**PLANNING ACT 2008  
THE INFRASTRUCTURE PLANNING (EXAMINATION PROCEDURE) RULES 2010**

**Application by London Resort Company Holdings for an Order granting Development  
Consent for the London Resort (ref: BC080001)**

**RELEVANT REPRESENTATION  
by the Port of London Authority**

Access, Rights of Way and Public Rights of Navigation Plans

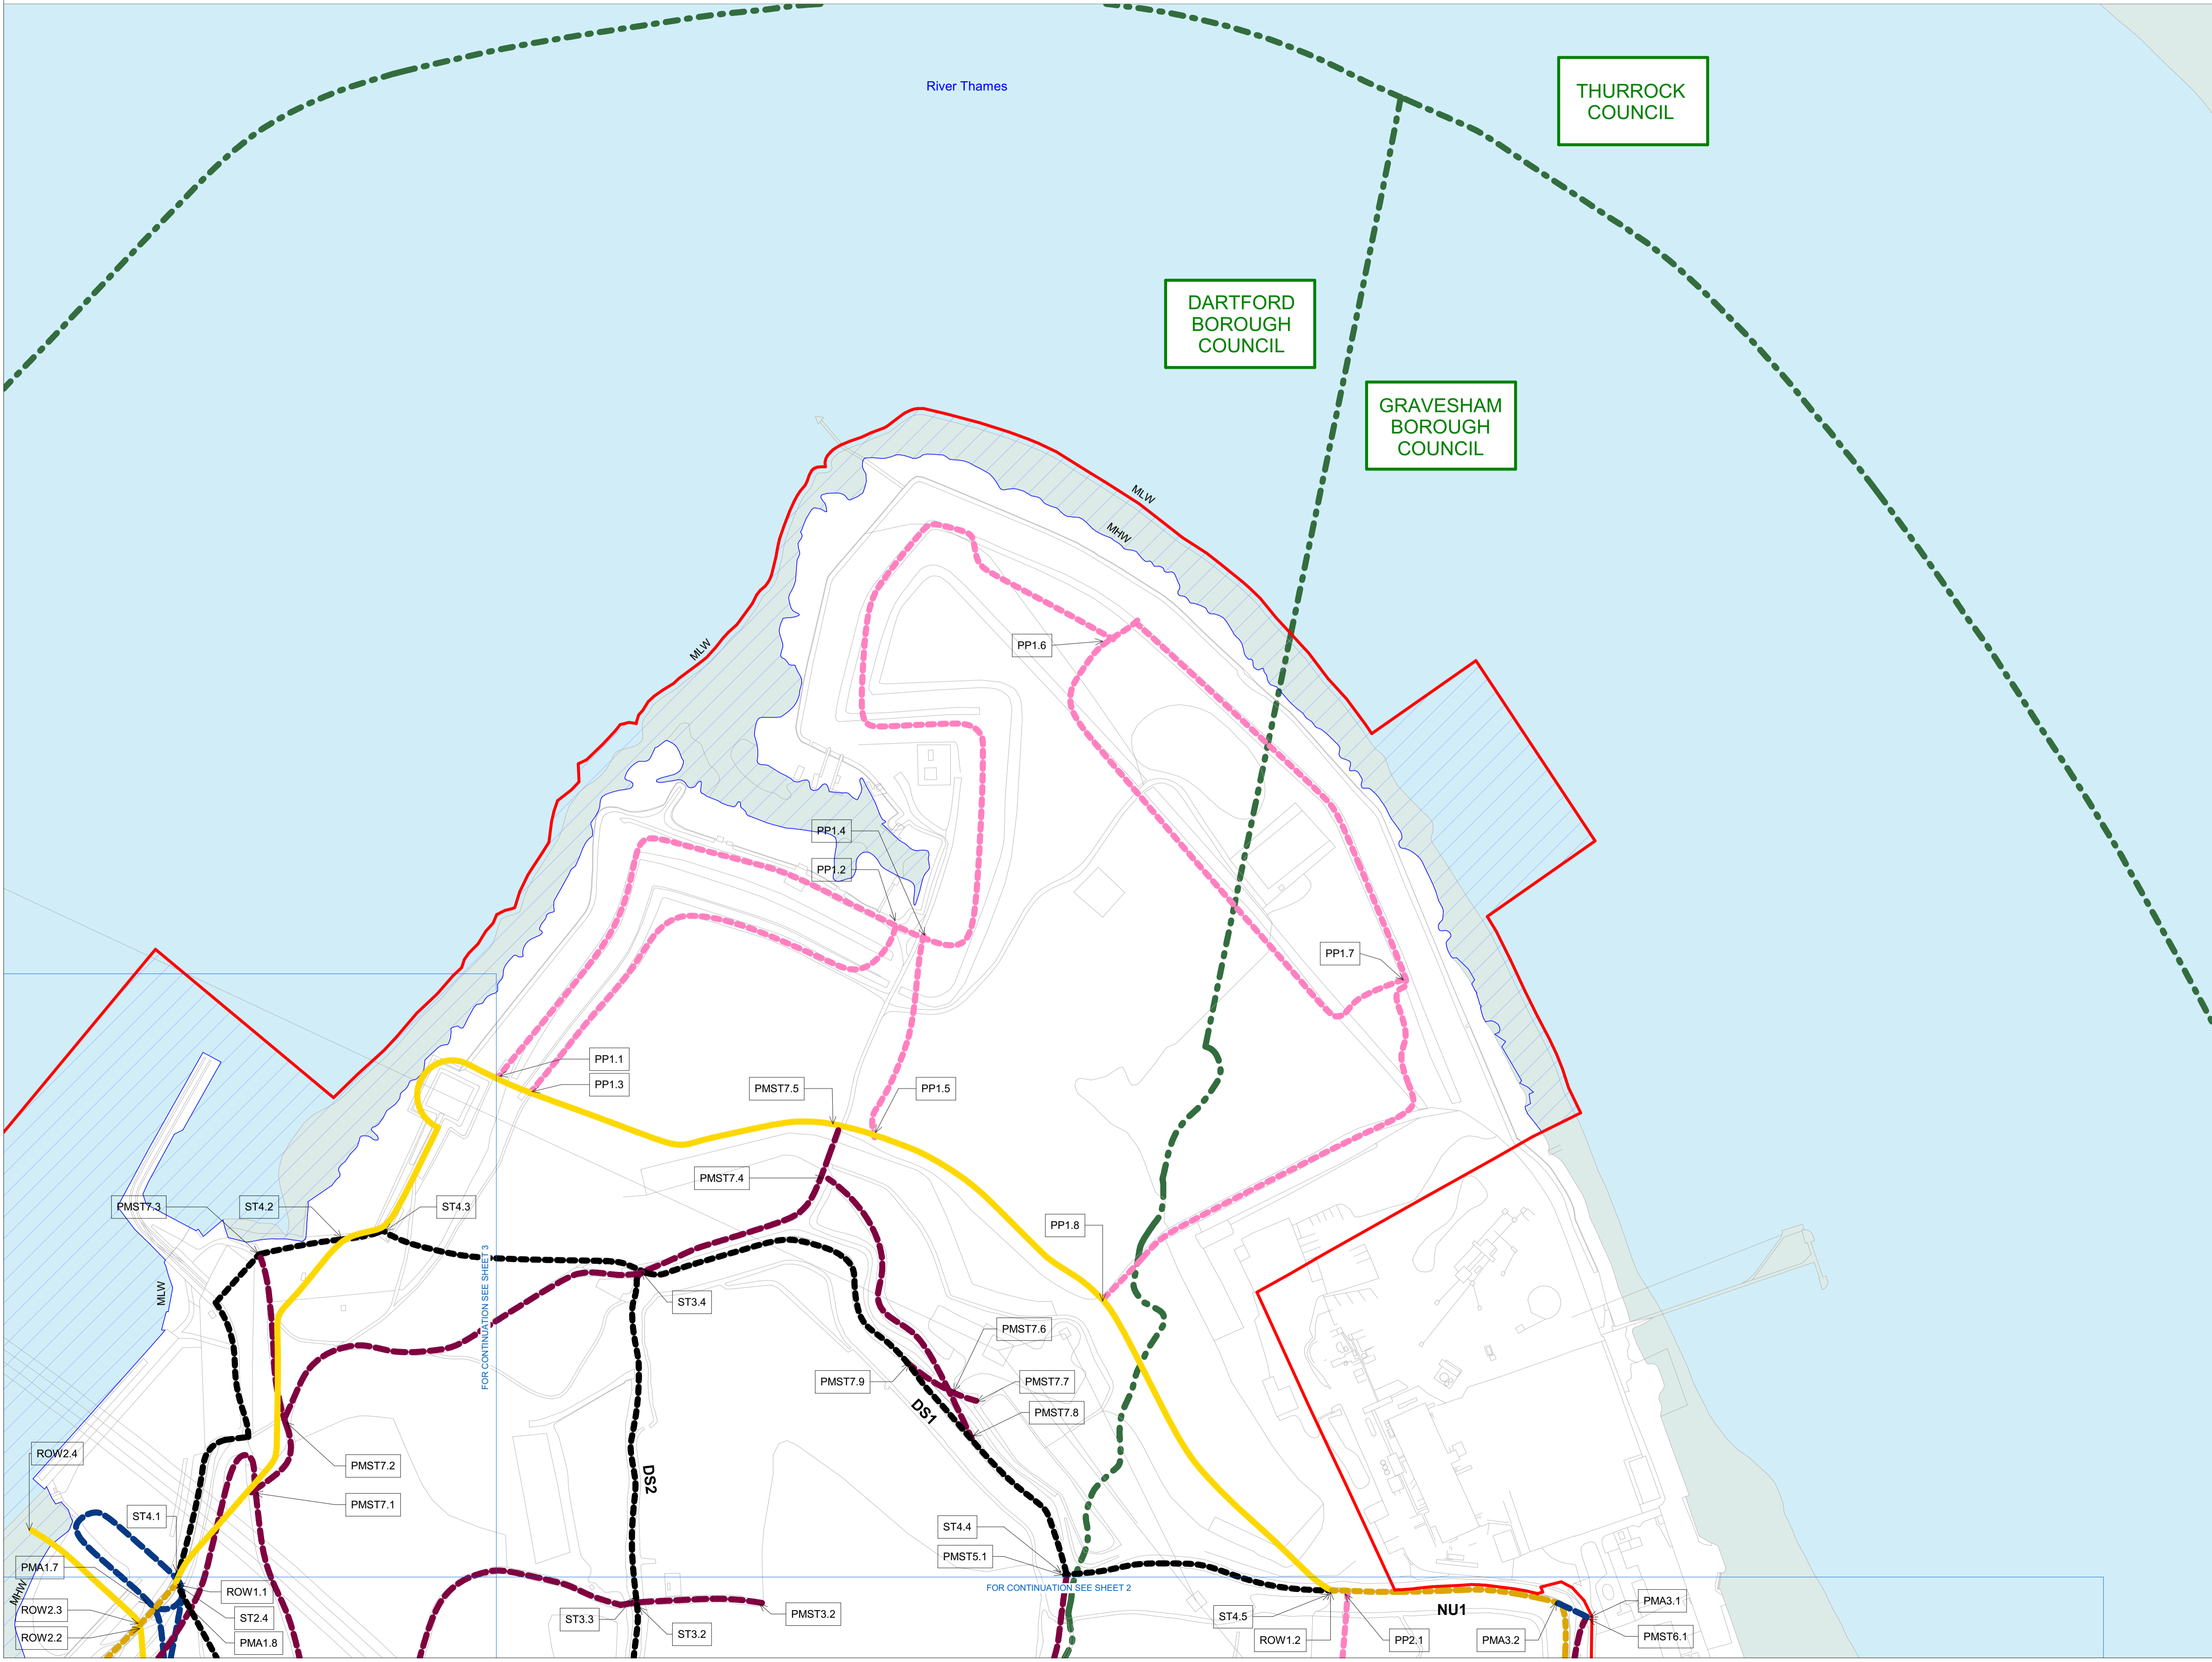
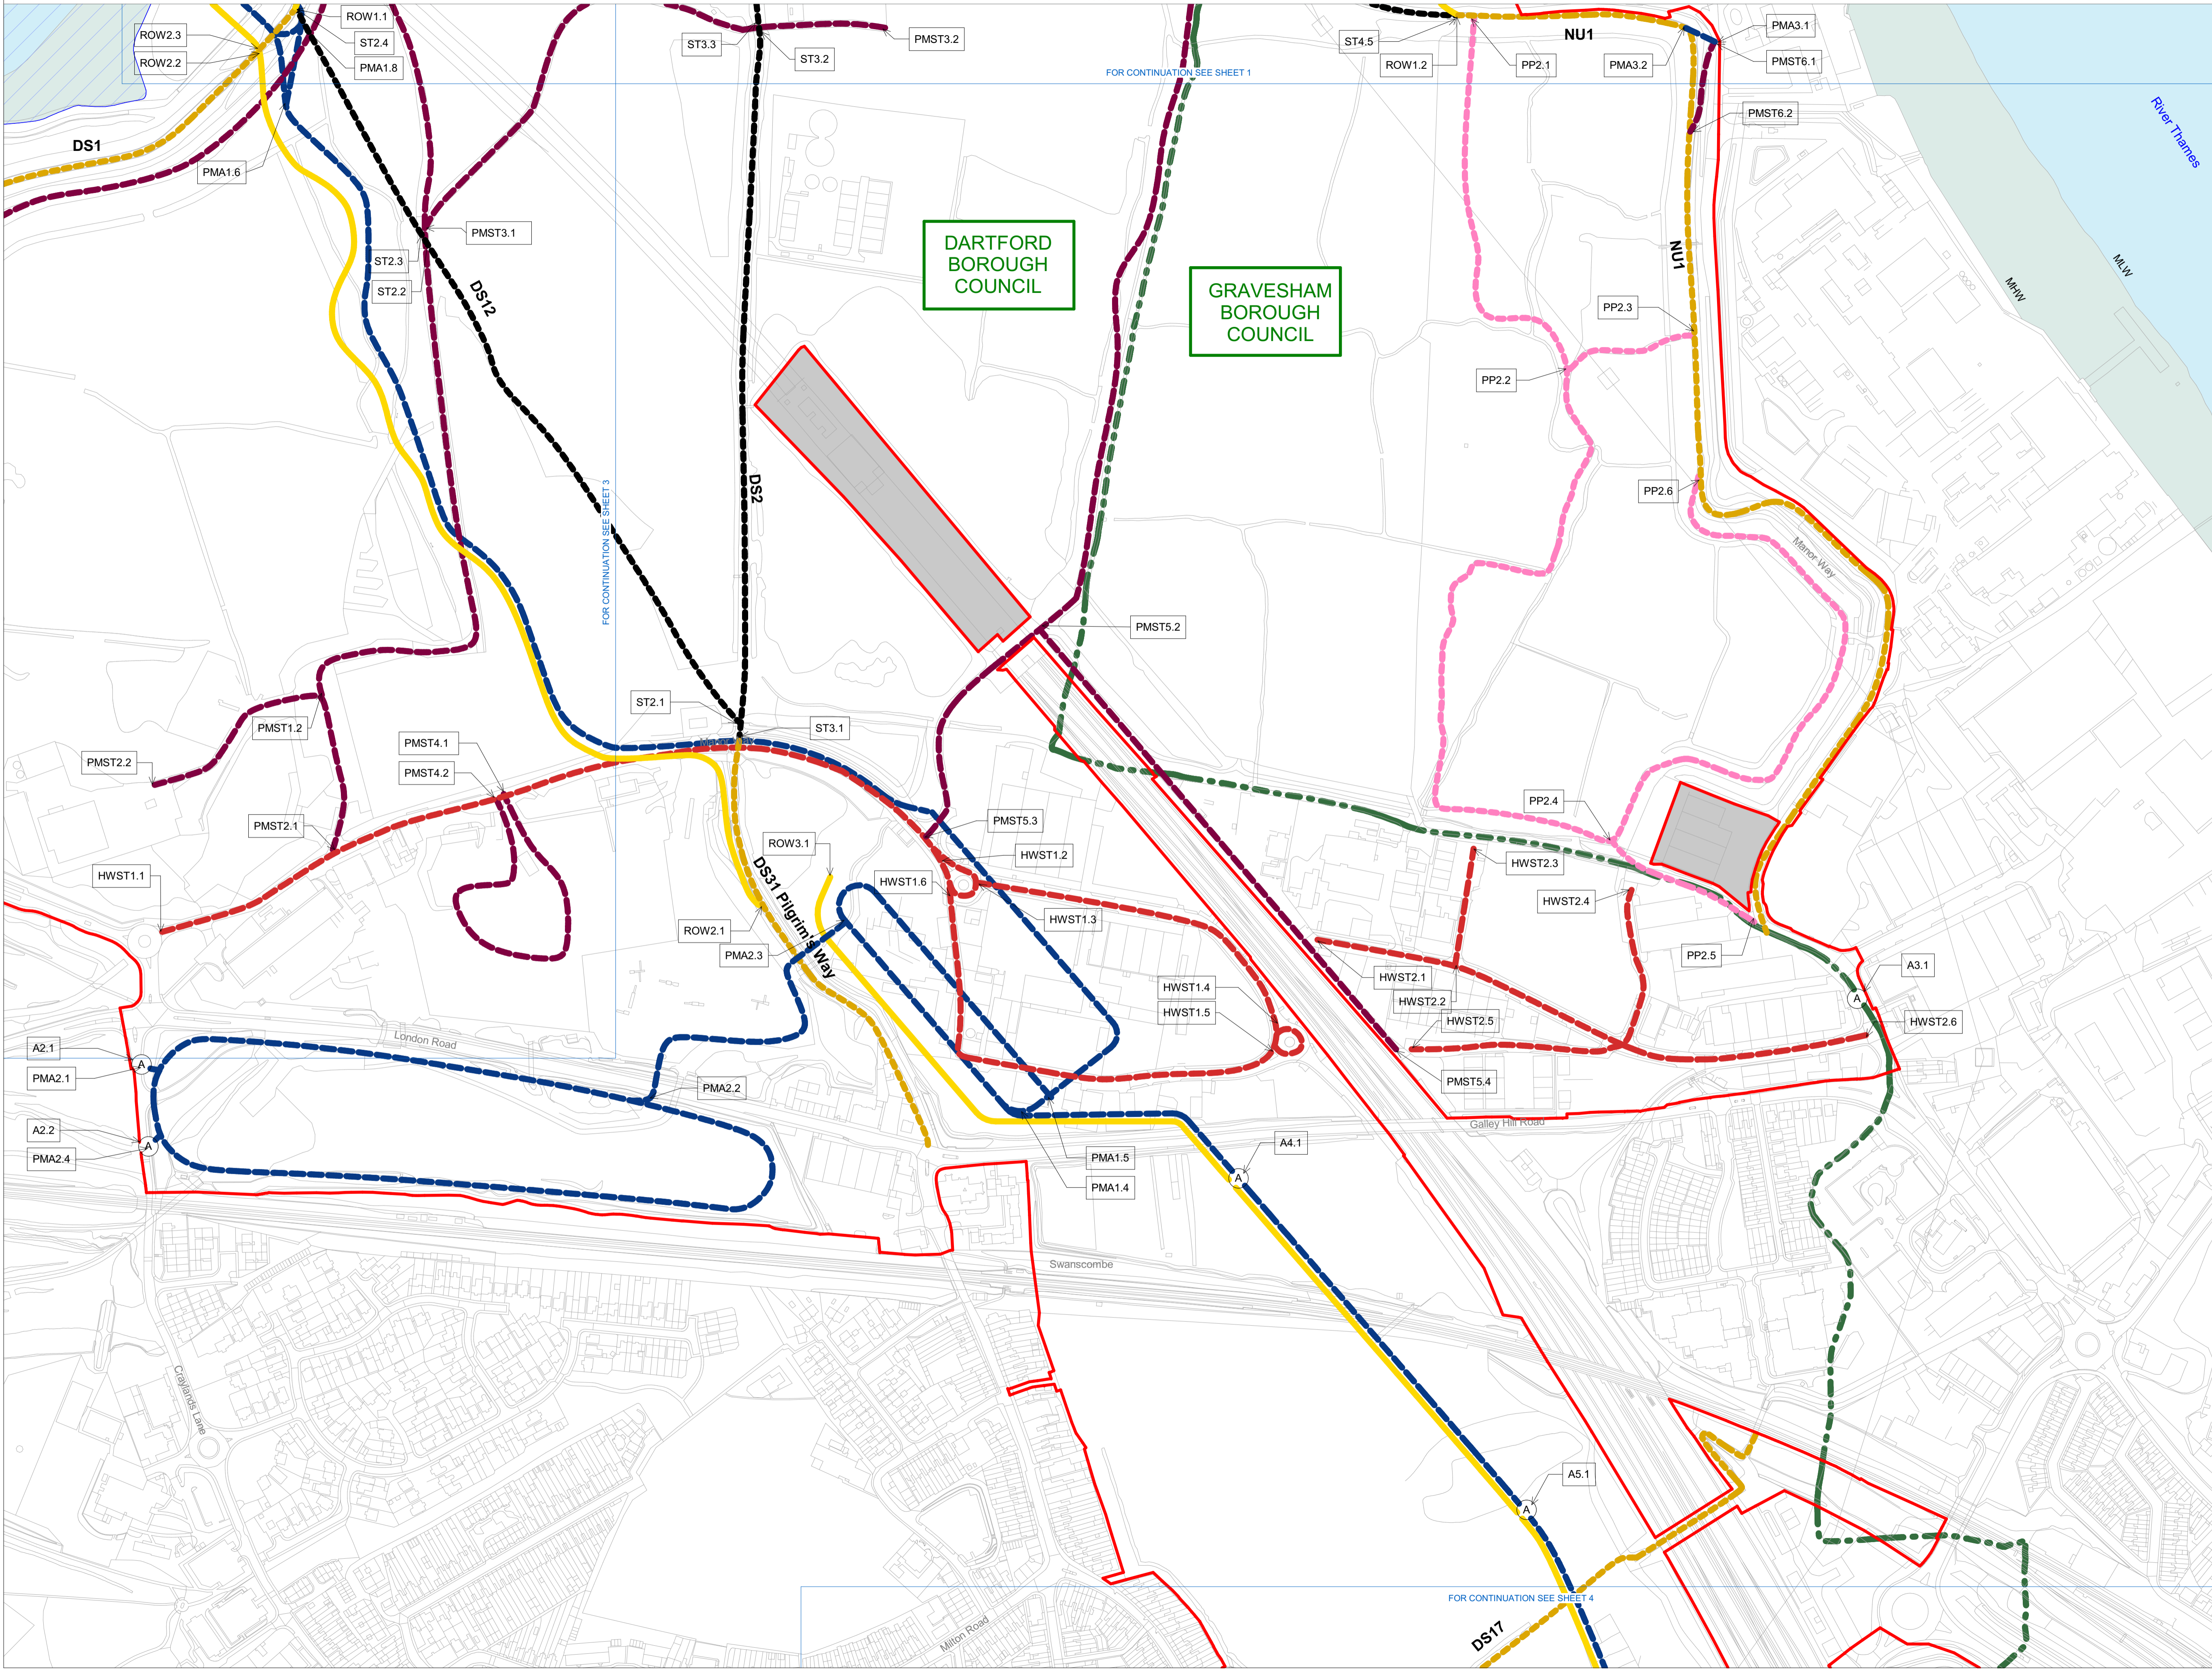
4. **Drafting of the Order and plans**
  - 4.1 The drafting of the Order and the plans submitted with the application fail to clearly indicate the applicant’s intentions regarding the river and its foreshore. There is insufficient detail provided in respect of works and operations within the river and foreshore to provide the PLA with certainty as to the nature and extent of those works and their construction, and also the scope and extent of any temporary works in, and possession of, the river.

of the disapplied provisions. The PLA takes issue with other provisions of the Order, including but not limited to: interference with/suspension of public rights of navigation (arts. 31(13) and 39); the amendment of existing byelaws (art. 49) and the making of new ones (art. 50); and the extinguishment of existing river works licences (art. 9(4)).
